Applicant: Mr Theo Fordham

Proposal: Installation of signage across two elevations including 3D illuminated sign (above the entrance door), a freestanding battery menu box and 3 no. window vinyl stickers

Address: Units 6 and 7 The Glass Works, Barnsley, S70 1GW

PROJECT DETAILS	
The Botanist - Barnsley	
DRAWING TITLE	
Proposed Signage Drawing	
DRAWN BY	
Michael Lovell	
DATE	SCALE
16/11/22	As stated @ A1
DRAWING NO	REVISION
NW22 - 13

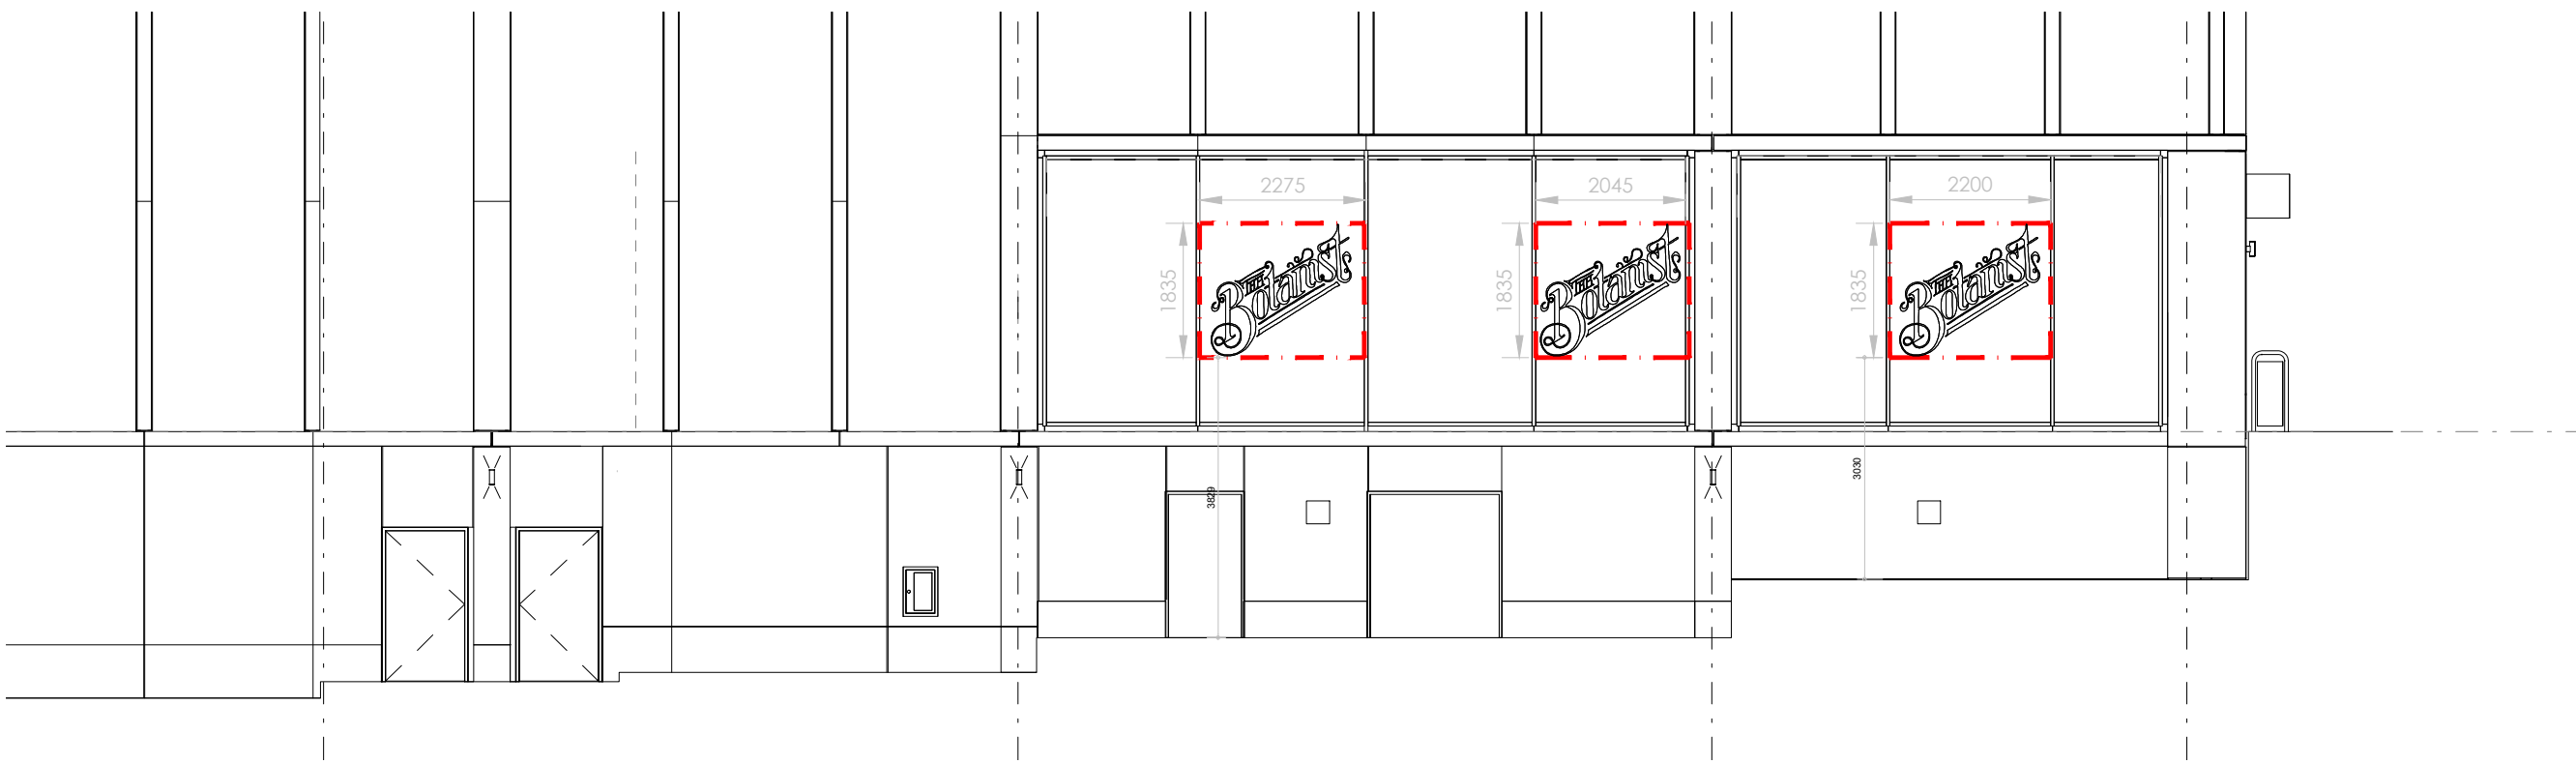
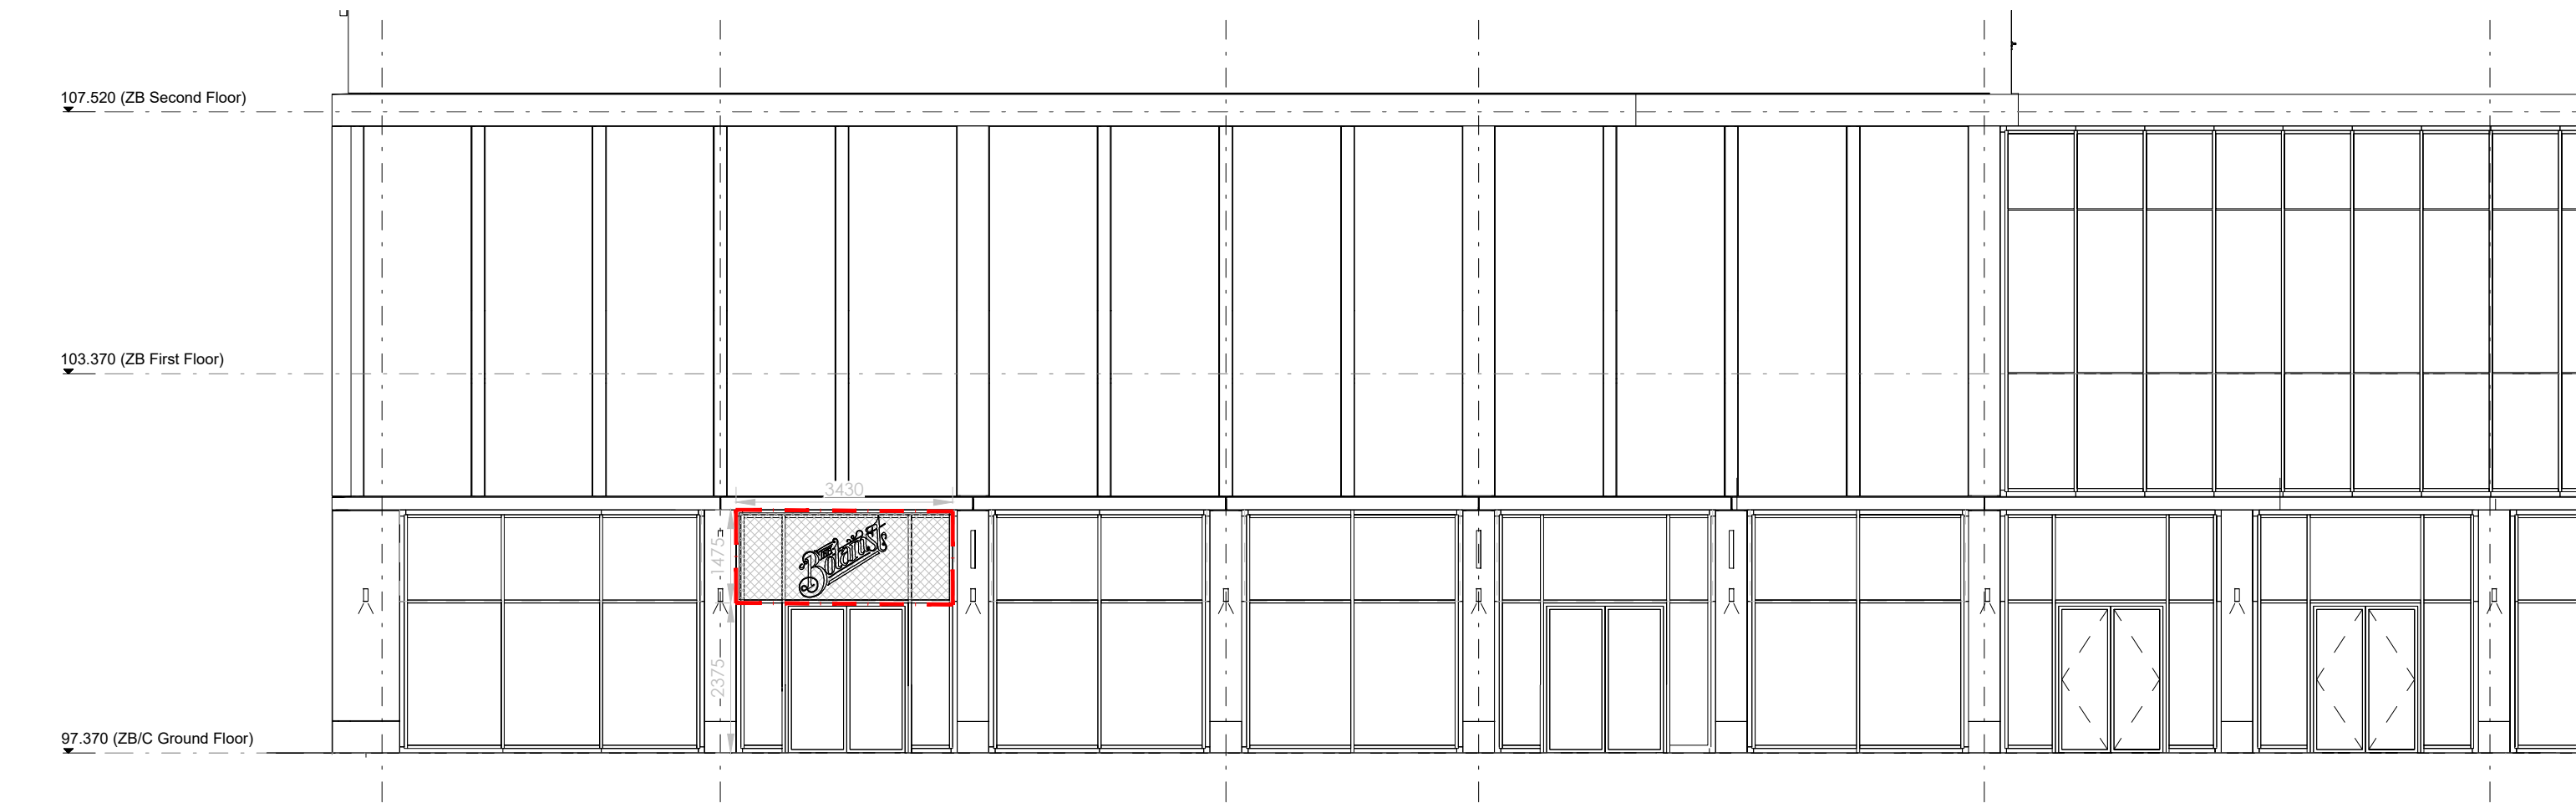
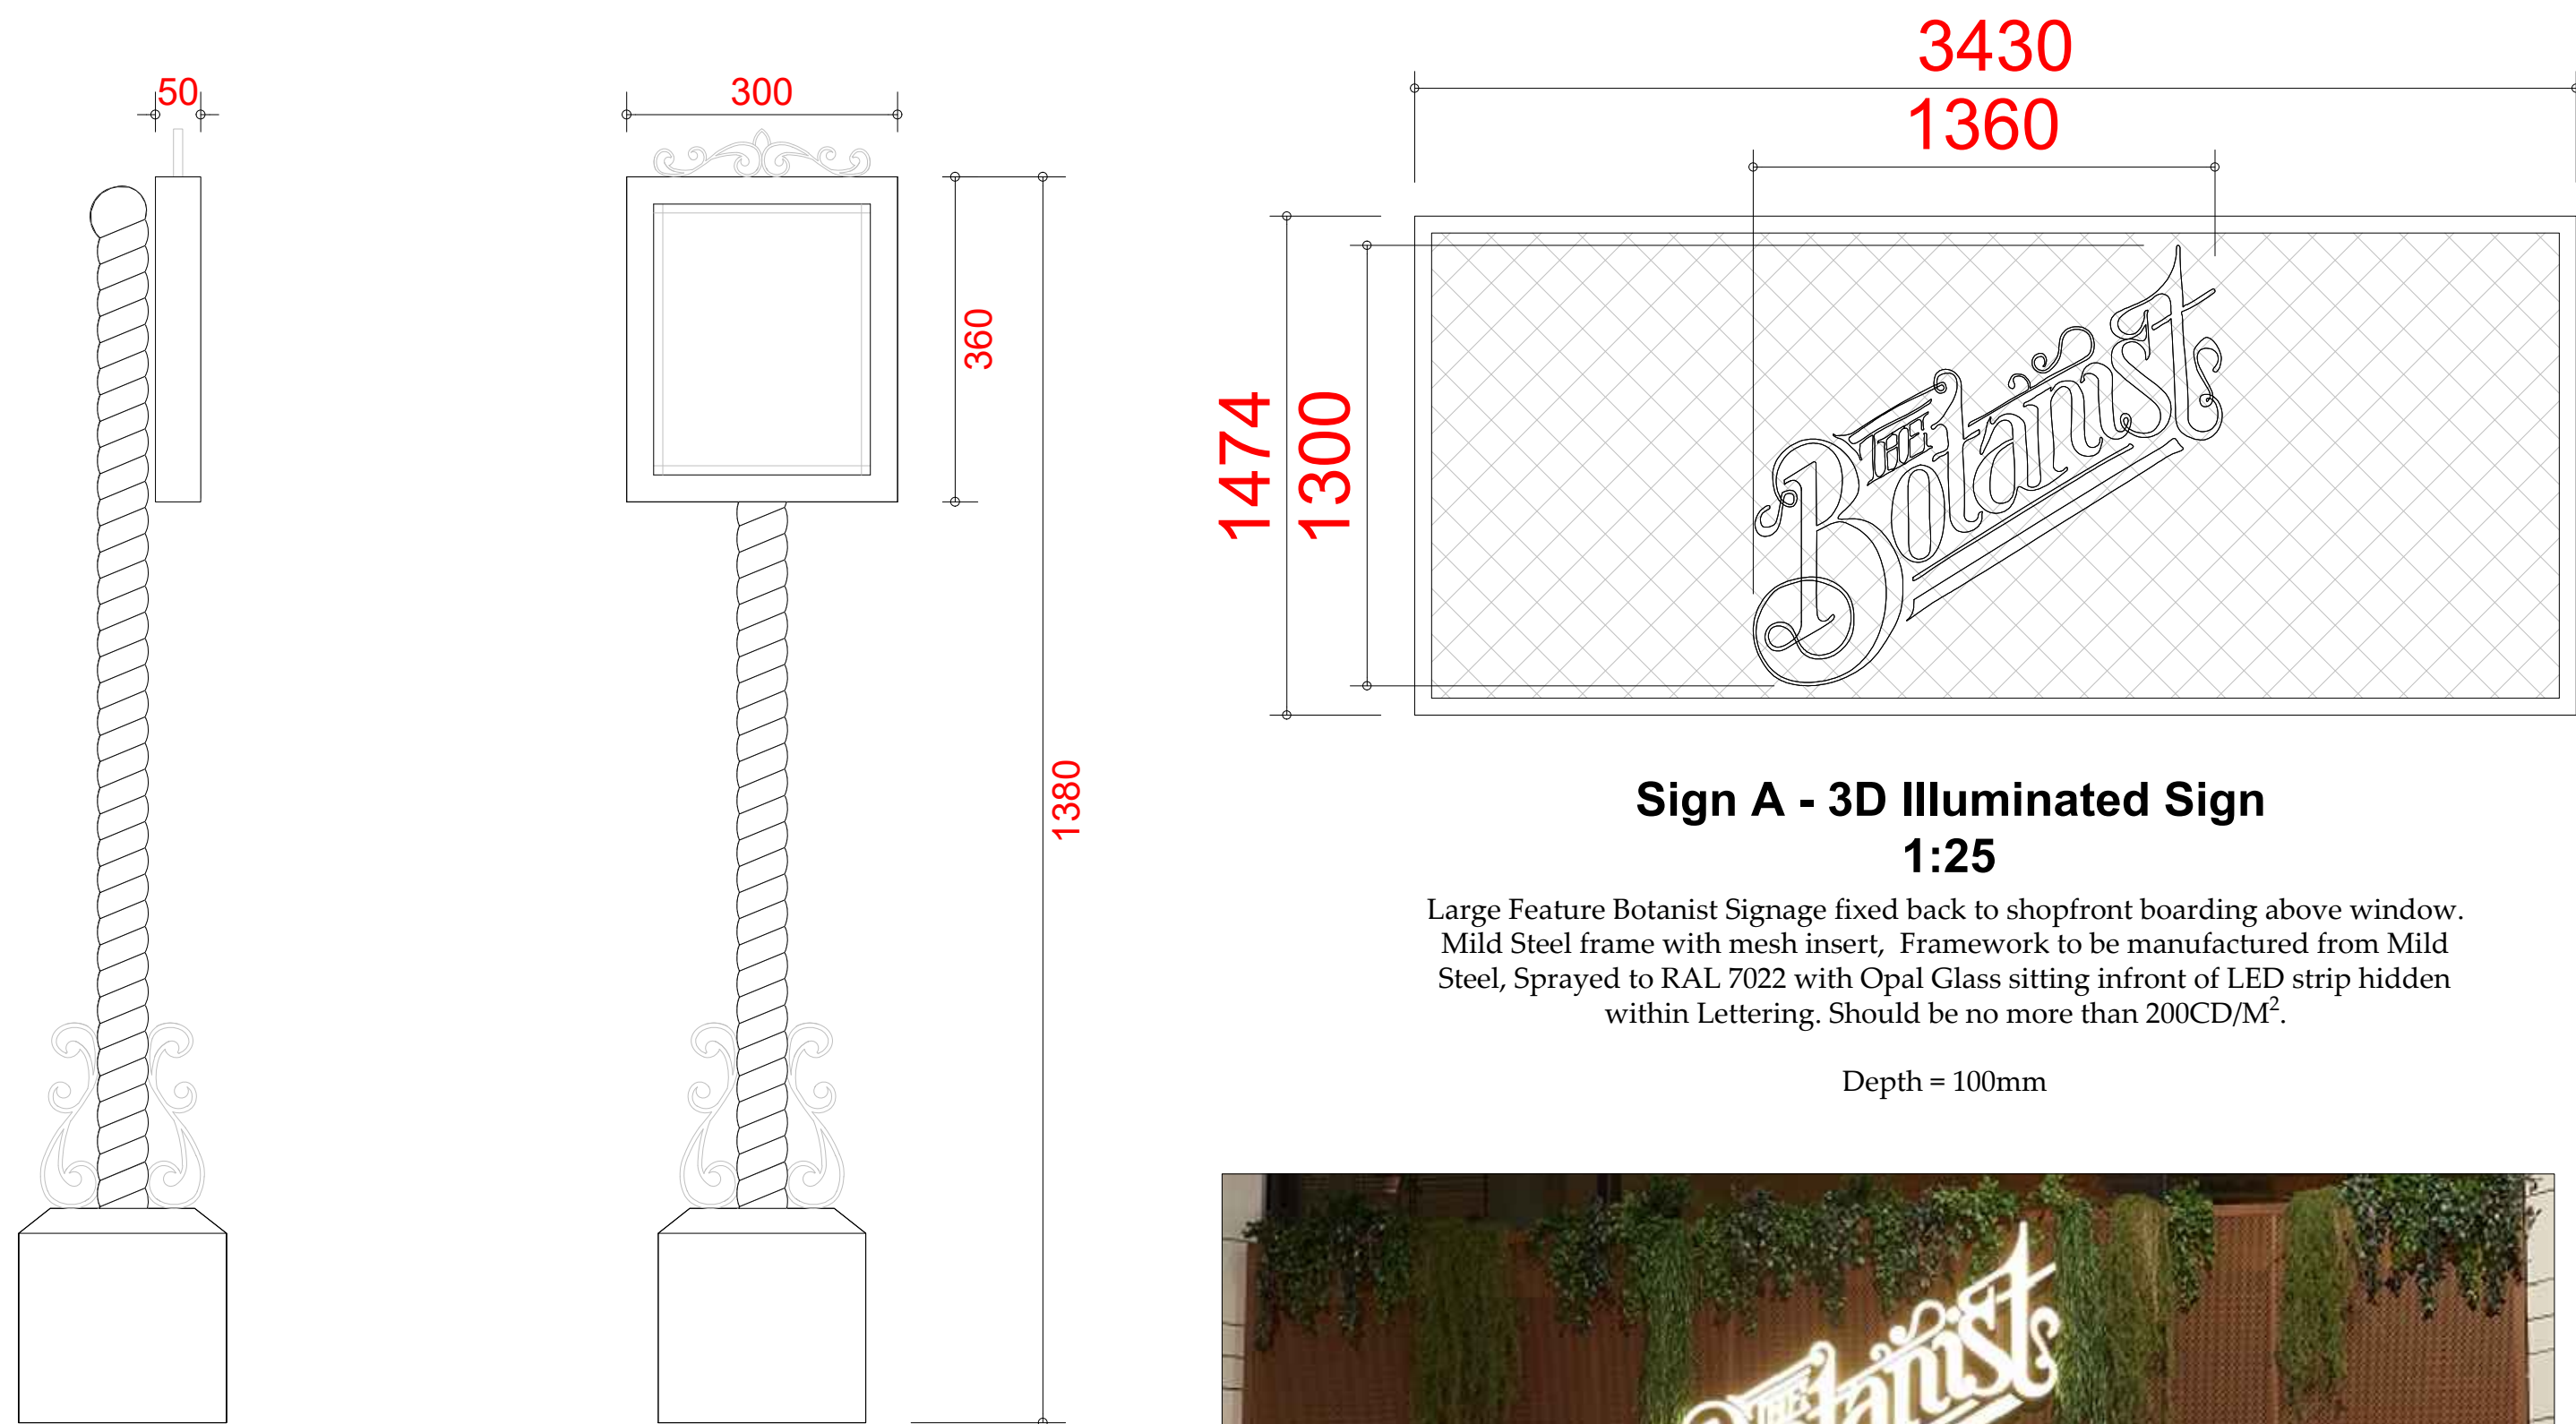
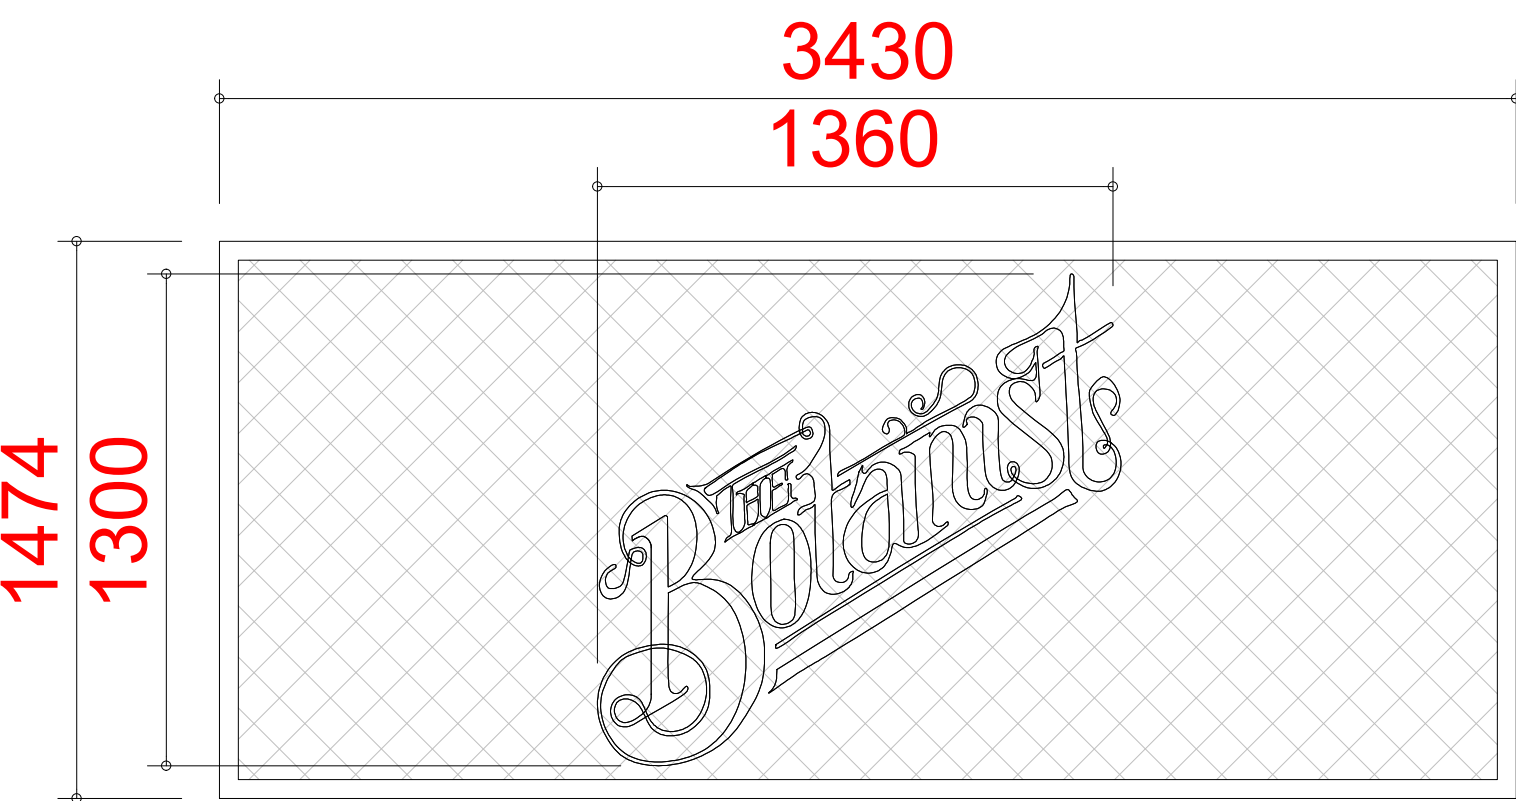
Design Officer: Initial comments: Expressed concern that the proposed signs did not accord with the guidance in the Shopfront Design Guide for the Glass Works, in particular in respect of the siting of signs outside the shopfront/on the public realm; and in respect of the repeated use of logos/retailers names and the extent to which signs retain the transparency of the Glass Works.

The application has been amended to reflect the advice of the Design Officer. It is considered that the proposed signs are of high quality, a good standard of design and appropriate illumination for their setting. The signs are considered to be acceptable in terms of their impact on visual amenity. Although the signs are not wholly in compliance with the Glassworks Shopfront Design Guide, it is accepted that overall, their appearance is acceptable and the signs are otherwise in compliance with the SPD Advertisements and Local Plan Policies GDA and D1. Conditions are recommended to ensure that the advertisements are displayed in accordance with the amended plans submitted; that illumination is limited as specified; and also to remove deemed consent for any further advertisements – this will ensure that any further advertisements remain under the control of the Local Planning Authority, in the interests of the continued satisfactory appearance of the property. The submitted drawings show an area of outdoor seating which was part of the planned layout and is already in place.
